The Wrens Nest
Underbank Lane
Stocksbridge
Sheffield
S36 2BS
21st August 2013.

Objection to Planning application 2013/0784 - 80 Metre Turbine

**Underbank (E)**

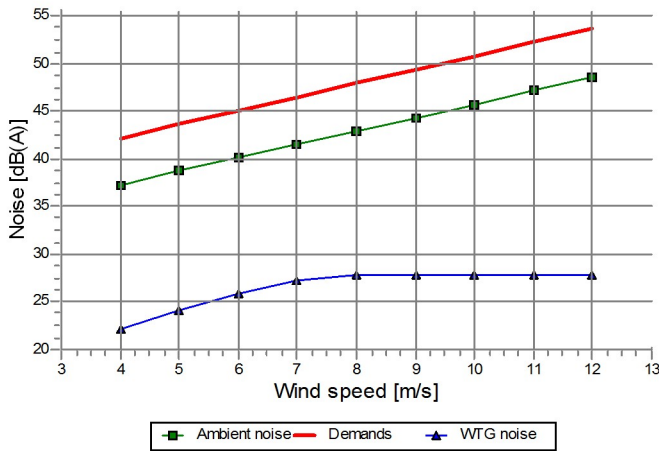
3. The fan proposed in the application documentation is smaller than that required for such a structure, therefore the noise readings given in the documentation are incorrect and misleading. Giving minimal noise levels.
